Submission to NSW Dept of Planning & Infrastructure Opposing PWCS T4 Coal Loader Preferred Project Report

7 November, **2013**

From: Newcastle Public Health Professionals

Figure 2. Signature 2 - Unloaded Coal Train Monday 14:42pm

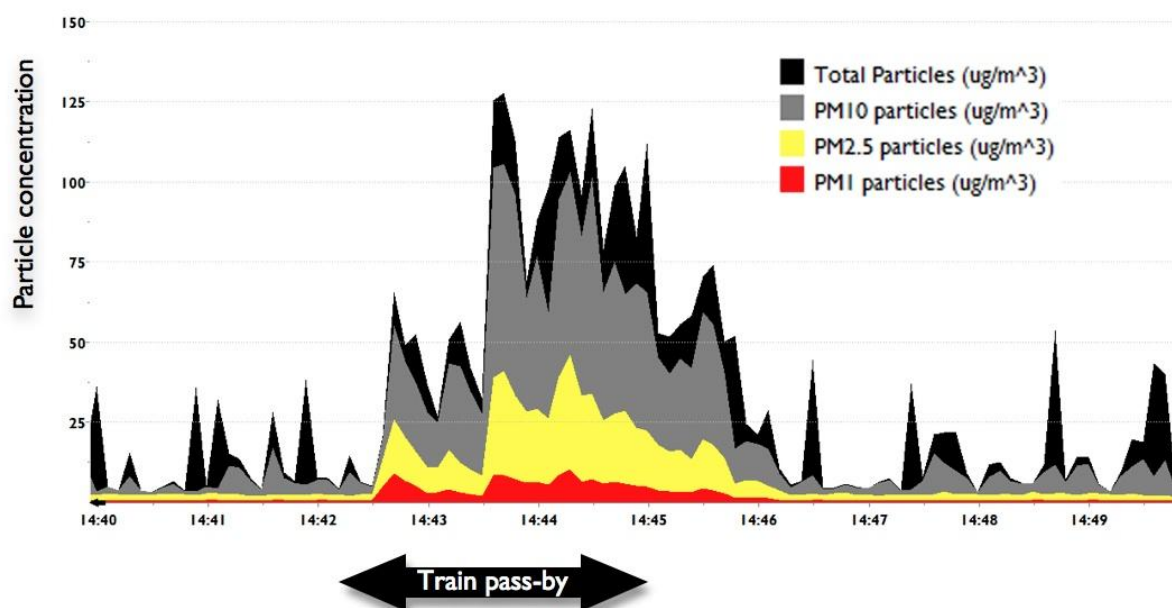
Signature 2 is indicative of an unloaded coal train pass-by. Unloaded coal trains generally approached the Beresfield Osiris monitor at higher speeds than loaded coal trains. This unloaded coal train (with 3 locomotives and 98 wagons) slowed to an average speed of 35km/hr. The wind was moving at 0.13km/hr and turned from N to the direction of the train, which was SE/SSE during the pass-by.

This signature shows two initial spikes in particulate matter with a one-minute delay and then a third, larger and more sustained pollution plume. The signature shows a clear indication of diesel emissions (PM1) and strong PM2.5 levels accompanying the high levels of PM10. The two-minute average of PM10 was $66.7 \mu g/m3$ compared to the two-minute average pre-train level of $6.6 \mu g/m3$. An entrainment of more than four minutes is noted.
